Nottinghamshire County Council

Local Impact Report – Steeple Renewable Project

Steeple Renewables Project
Figure 1: Proposed Trench Plan and Geophysical Survey Interpretation Data

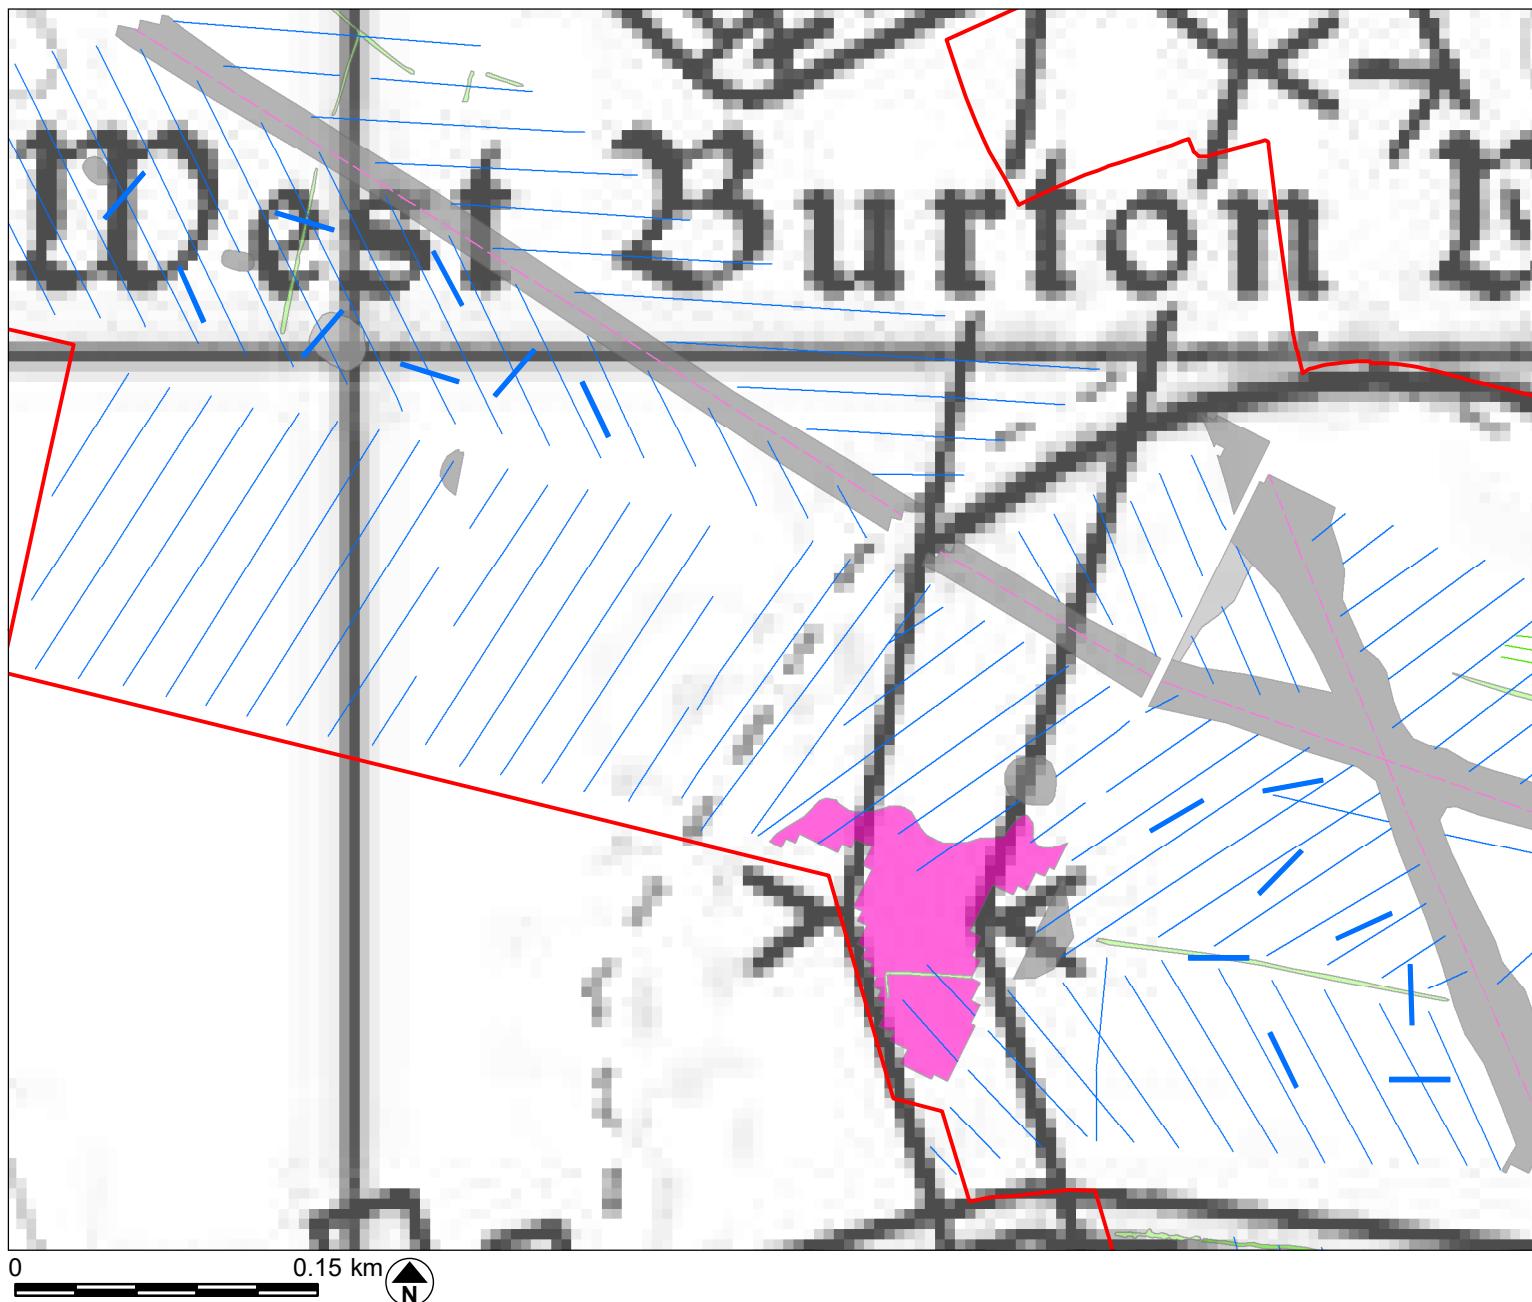
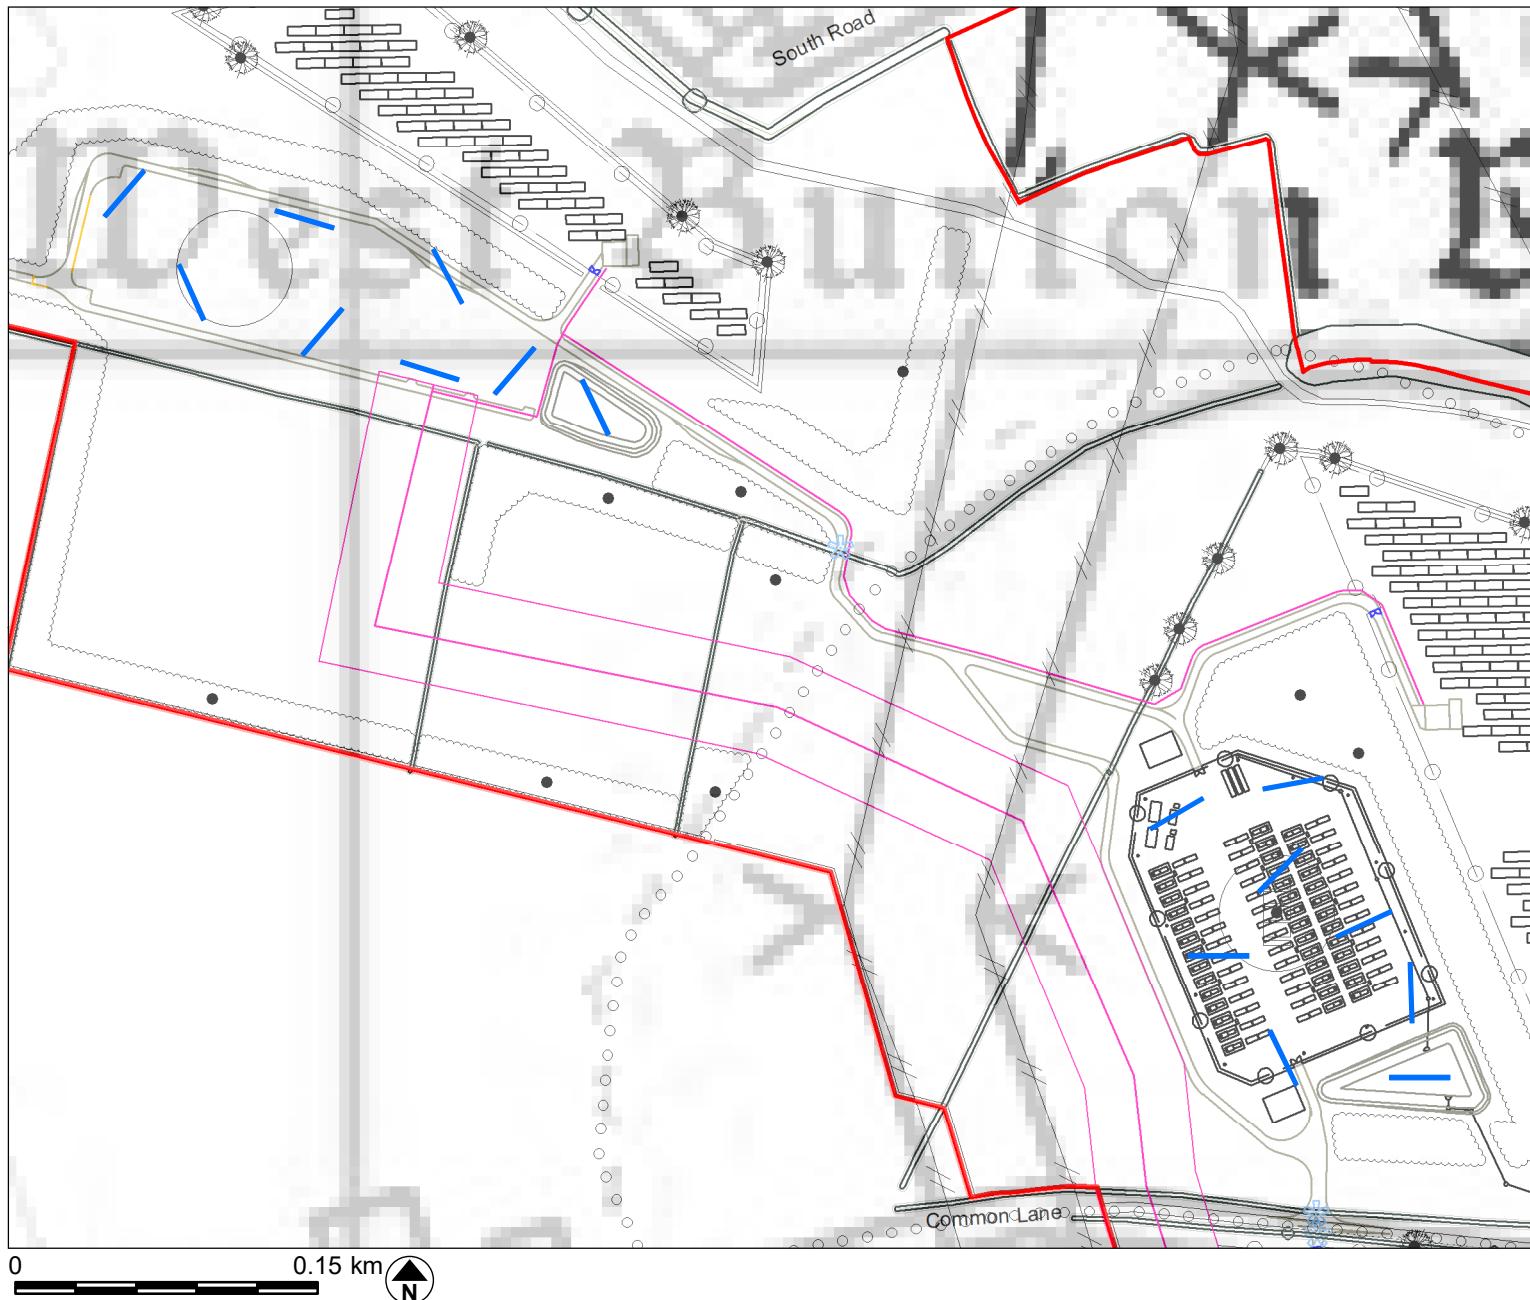
- 5.2.9. **The applicant has recently undertaken limited trial trench evaluation of the BESS and substation compounds comprising 16 trenches. While this is welcomed, the overwhelming majority of the site remains un-evaluated and in a state where the applicant does not understand the archaeological resource sufficiently to assess the proposed development impact.**

- 5.2.10. The pre-determination trenching is confined to the BESS and substation area and does not include other areas of infrastructure such as new roads/tracks, cable trenching for both for connecting rows of panel arrays and for grid connection, or for landscaping and ecological management areas. It also fails to include the areas of archaeological sensitivity that their own assessment work has identified.
